Application No: FG/105/25/PL  
Site Address: Yeomans House Littlehampton Road Ferring BN12 6PB  
Description of works: Proposed change of use of existing ground floor offices to Mazda showroom with showroom extension to front of building. This application is in CIL Zone 3 (zero rated).

Ferring Parish Council wishes to submit the following comments in response to planning application FG/105/25/PL  
:

Drawing No. G002-01 Rev.

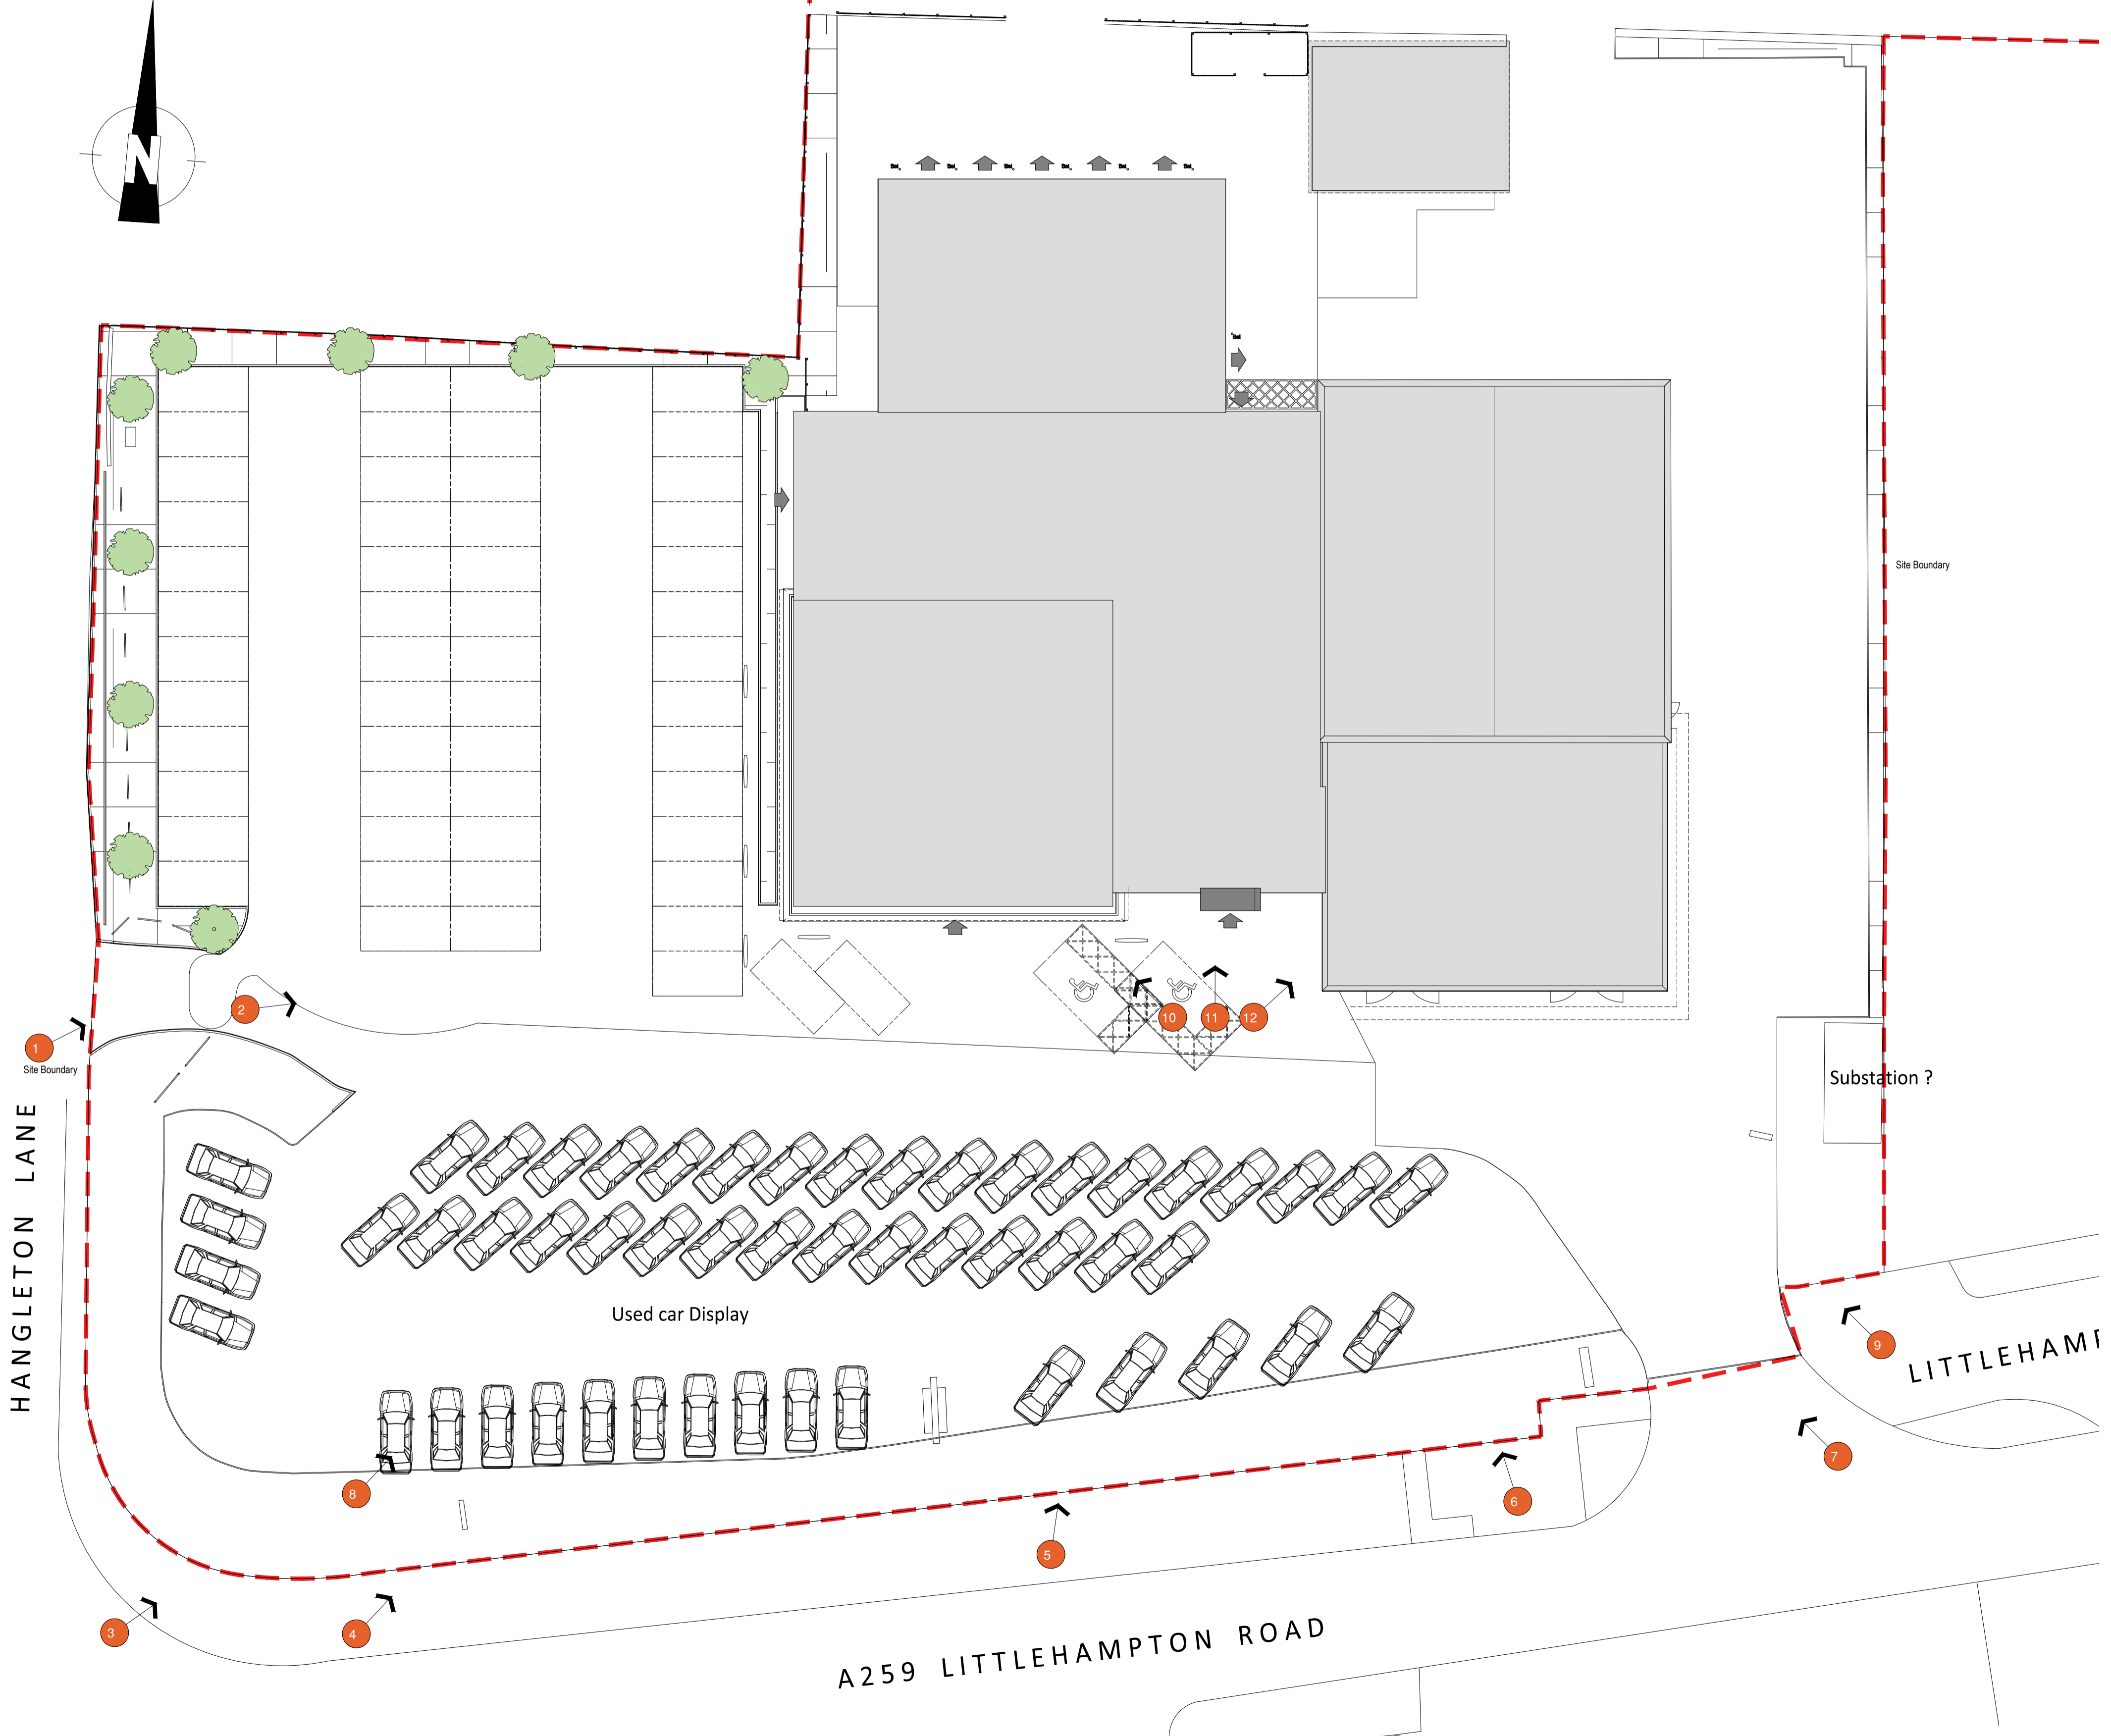
However, we note with concern that the existing site layout includes two disabled parking spaces, which appear to have been omitted in the proposed layout.

Drawing No. G002-10 Rev. -

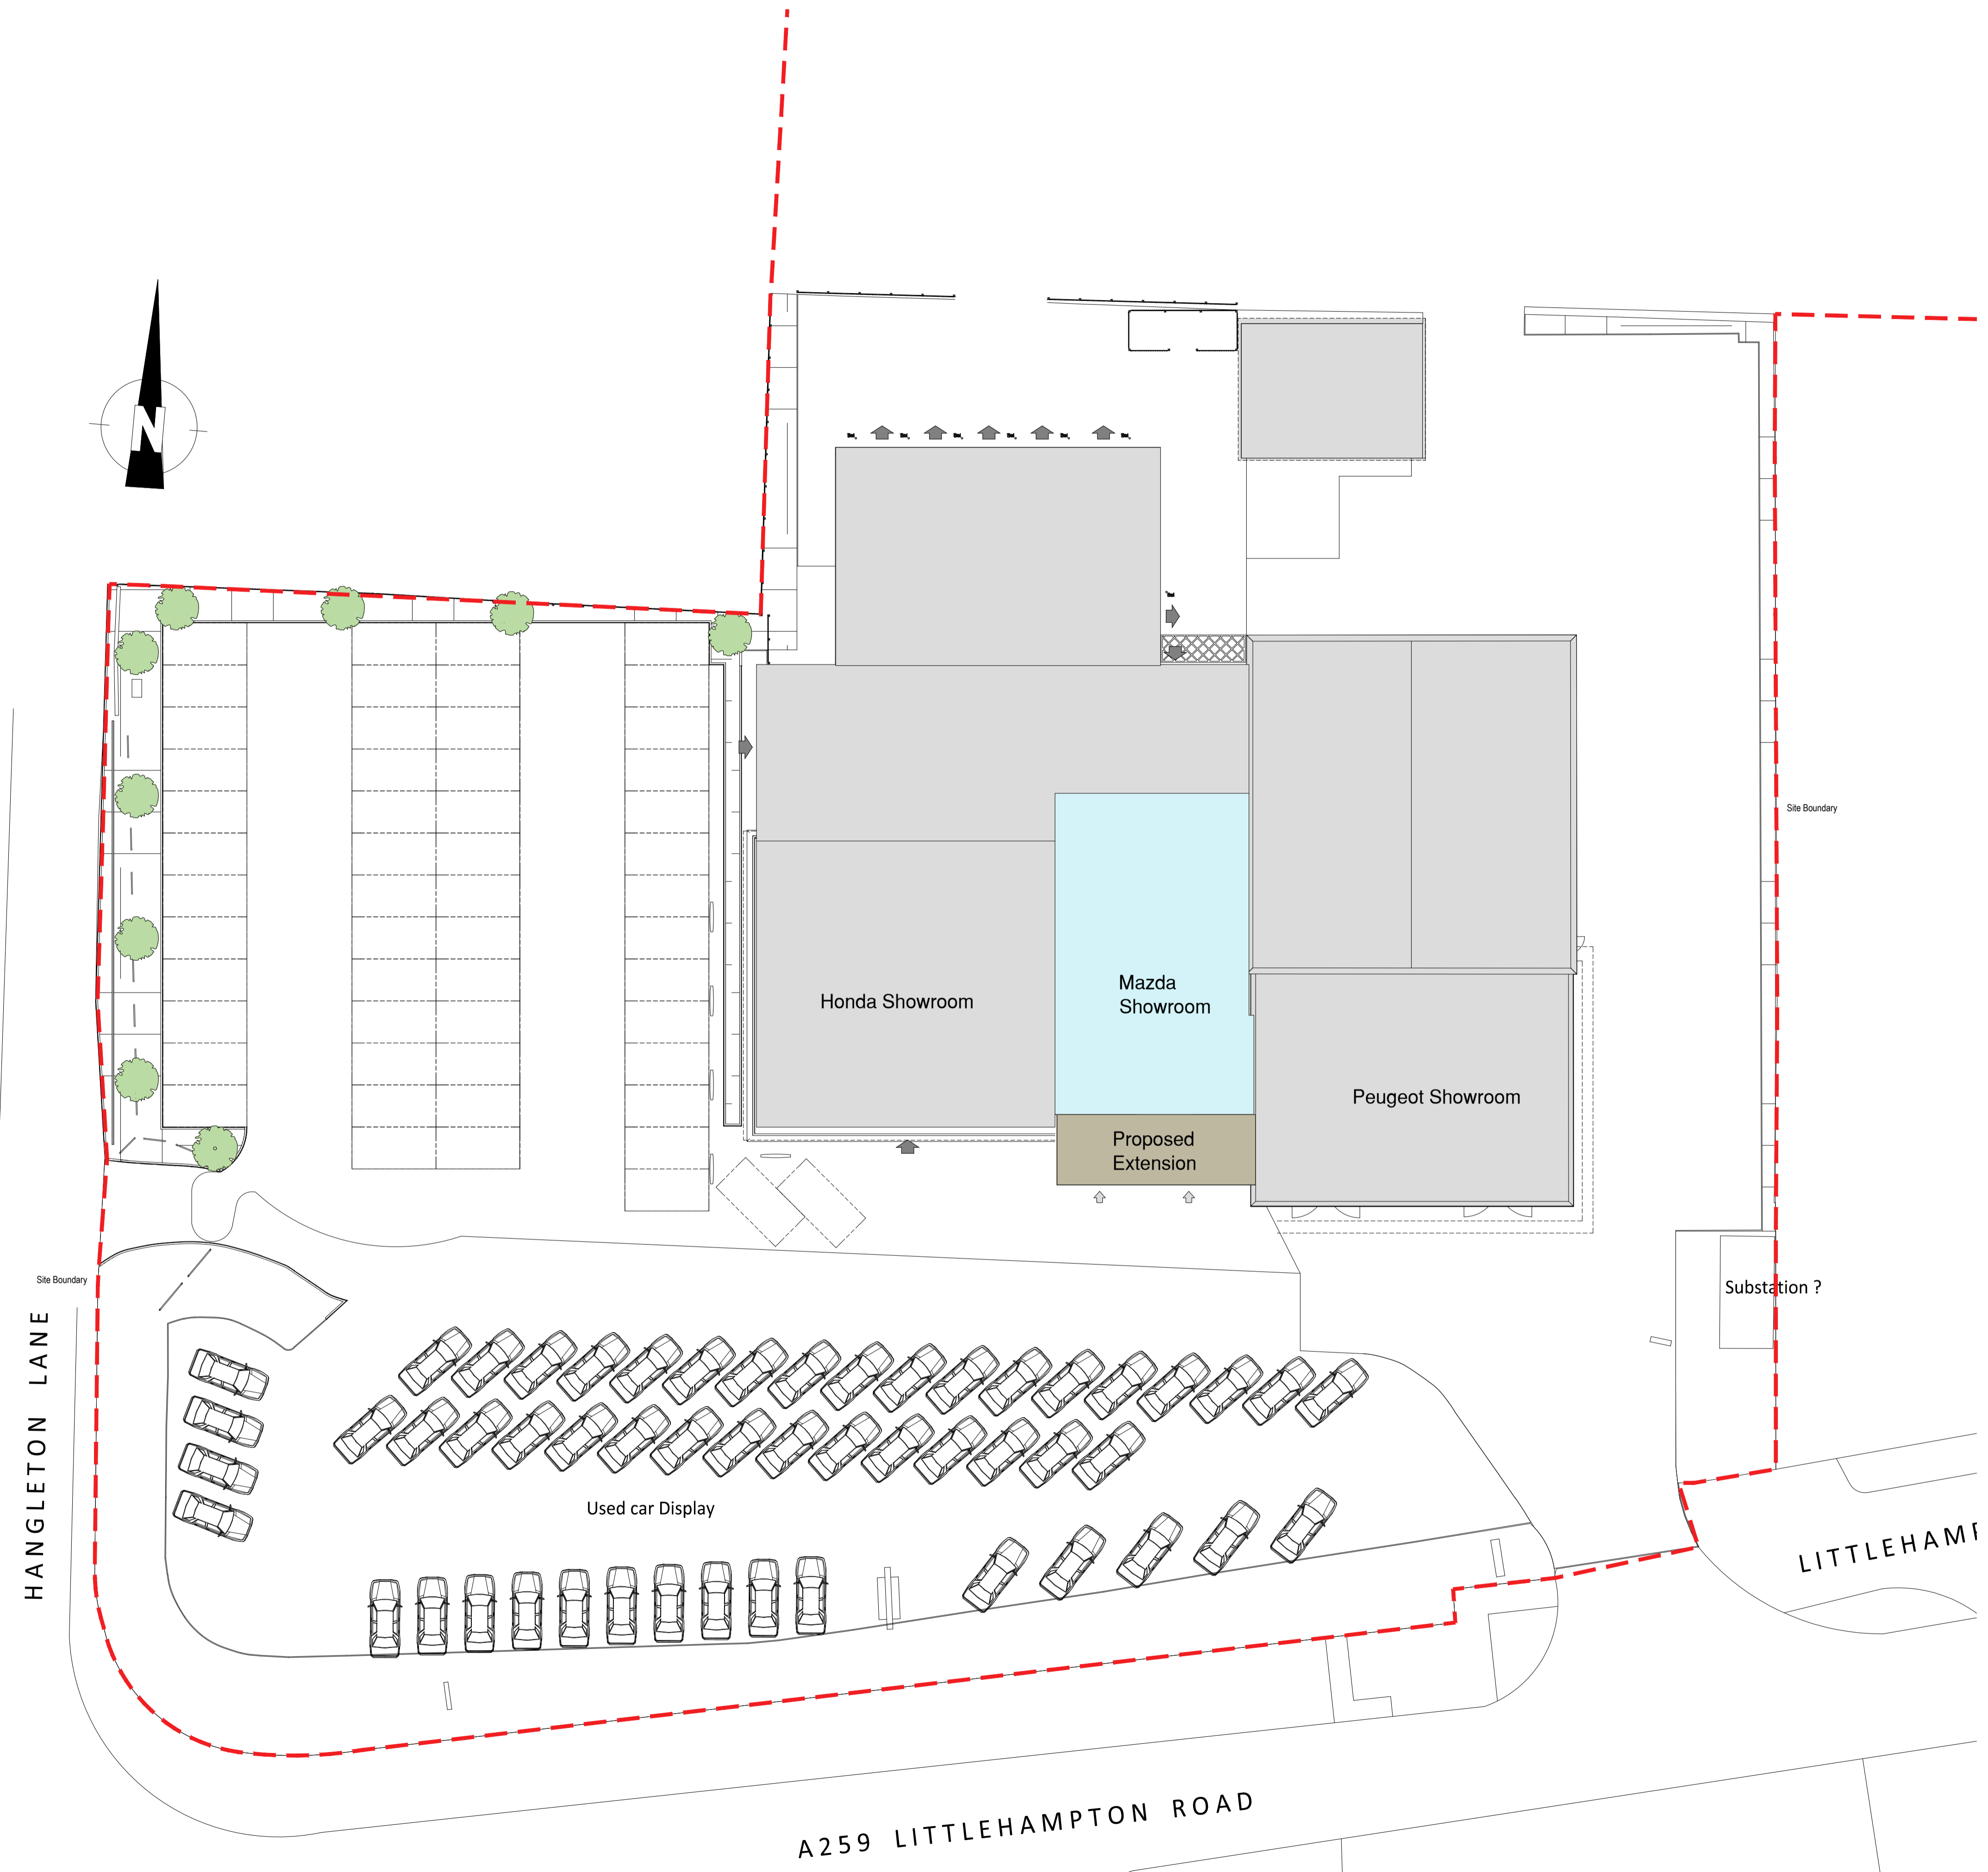
In the interest of accessibility and compliance with equality legislation, we urge that the provision of disabled parking spaces be retained in the revised layout.
